Gibson Administrative Relief, ADM-19-010

Please accept the following comments from El Paso County Public Health regarding the project referenced above:

SITE PLAN

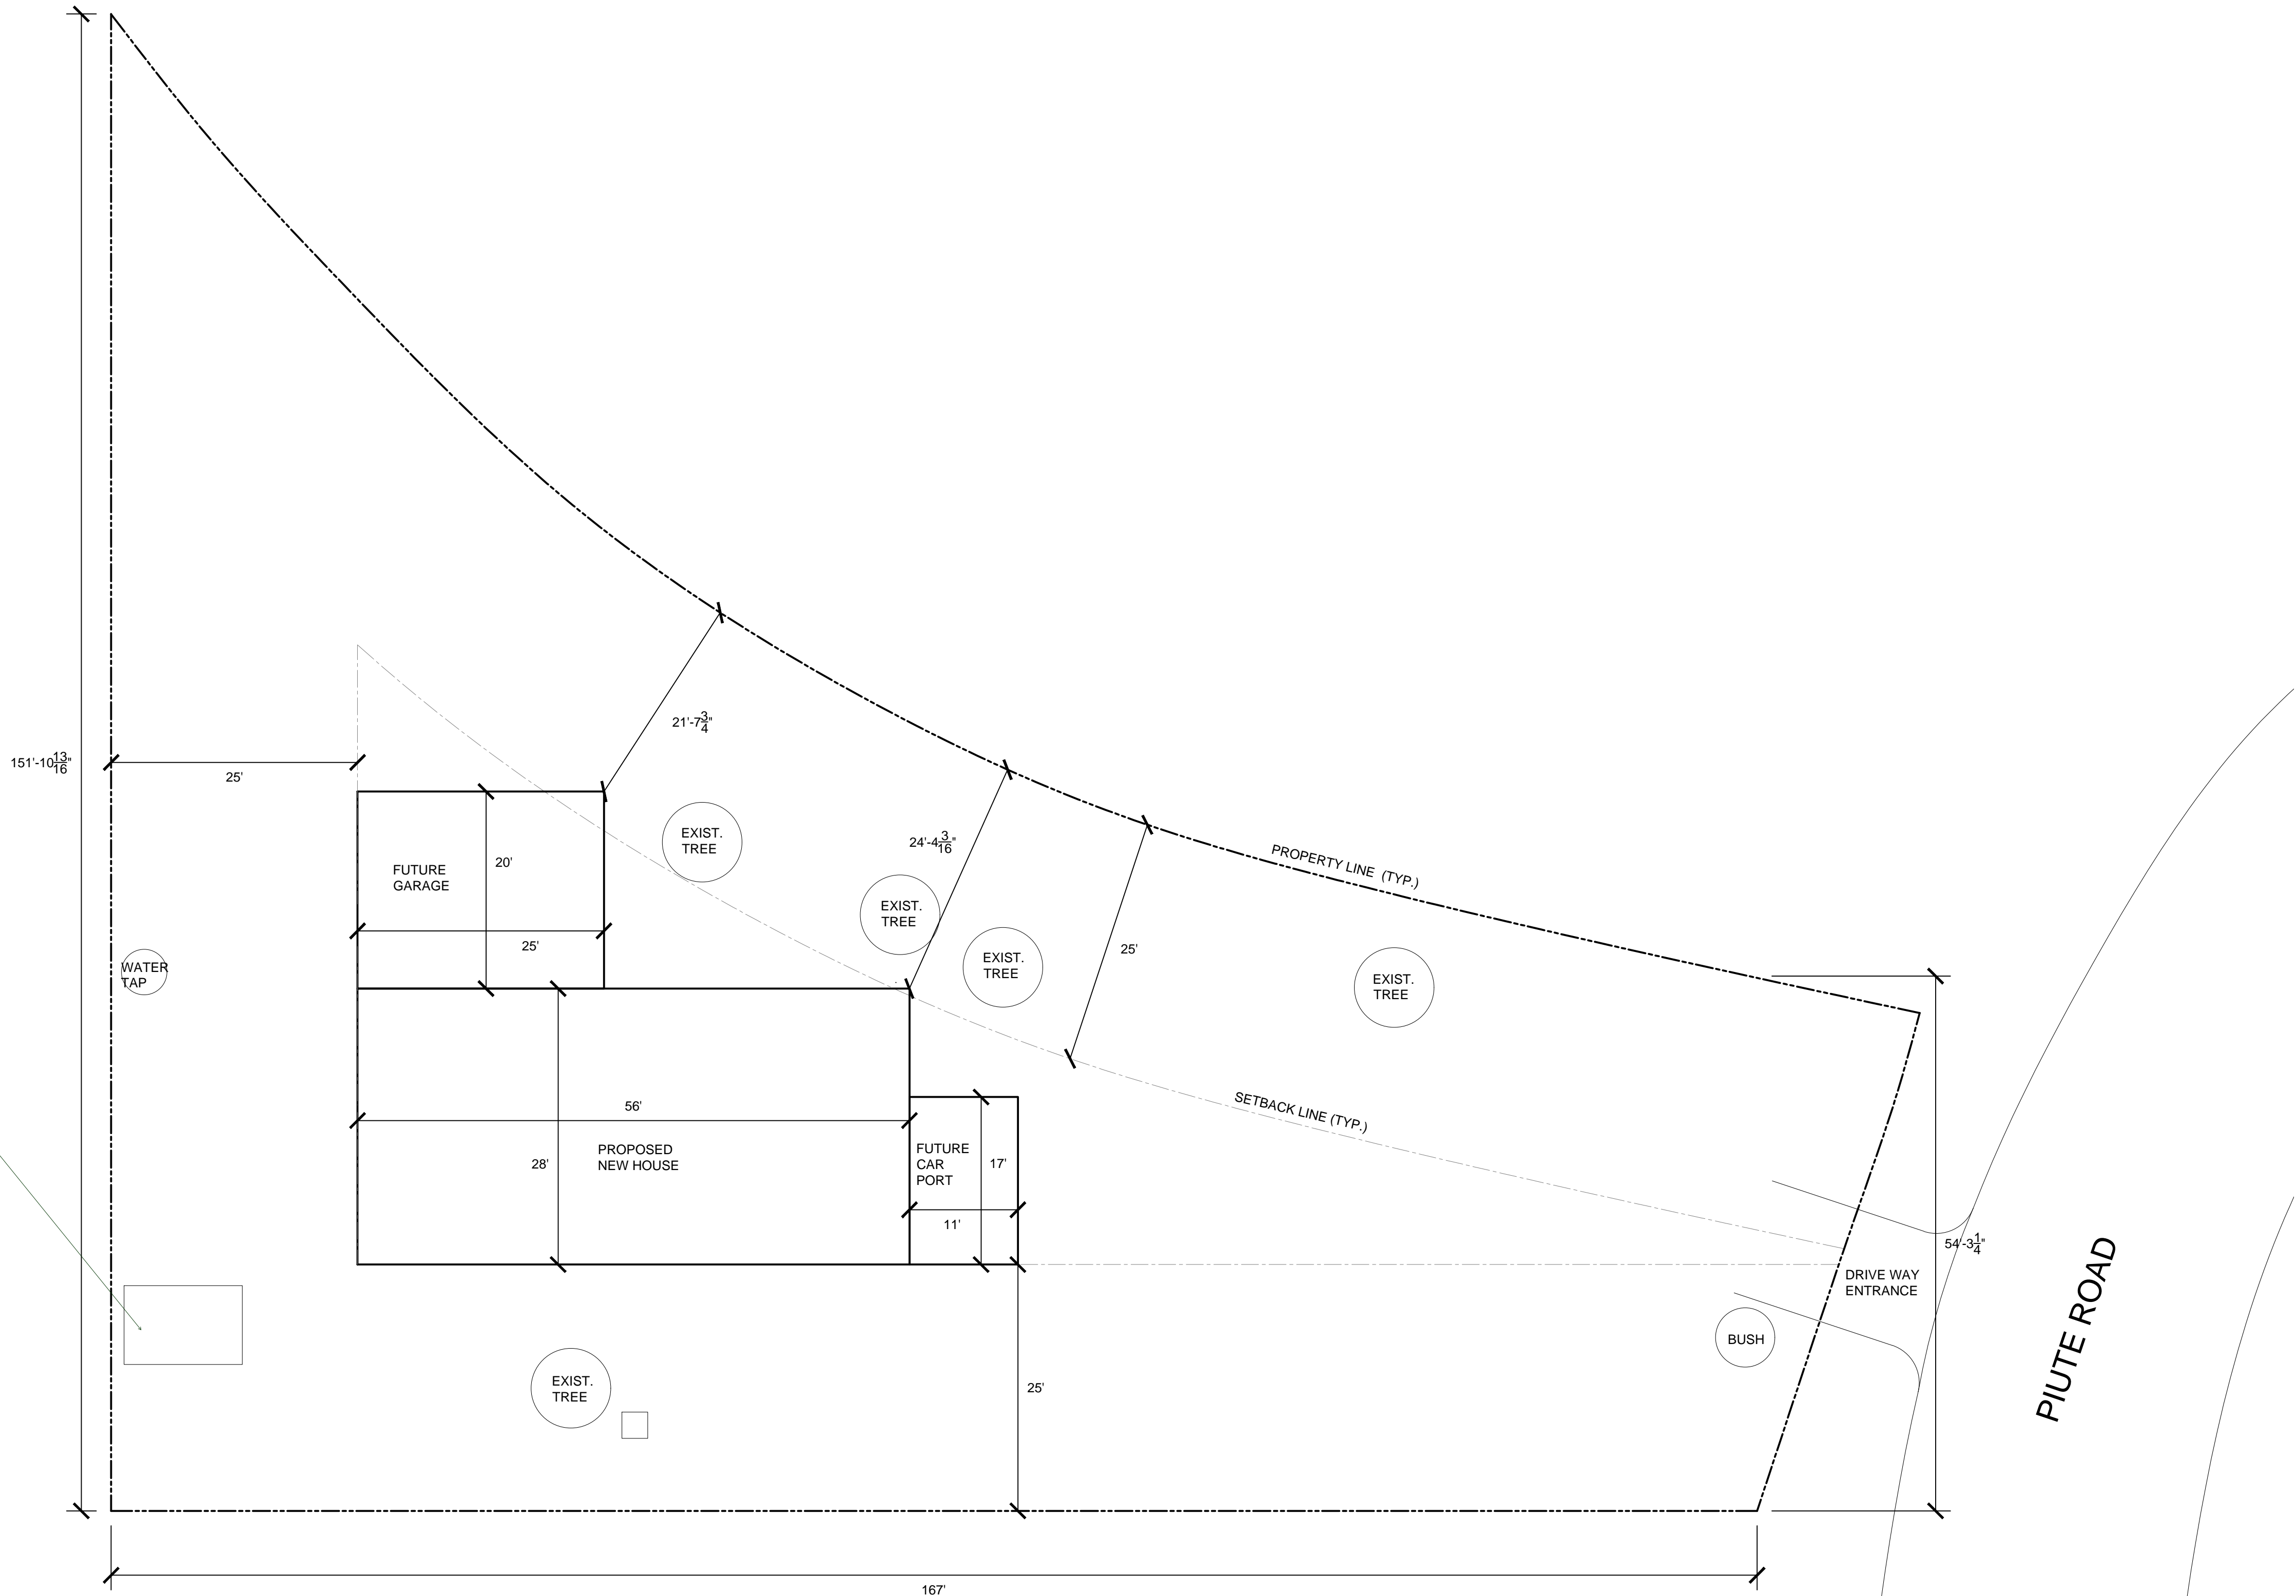
- **No public health issues noted with this setback request; however, the type of wastewater service for this property was not identified in the submittal. If the property has an OWTS for wastewater service, then the soil treatment area (STA) must be located and protected. Advise contractors not to drive or park on the STA. Compaction of the soil treatment area often leads to premature system failure.**
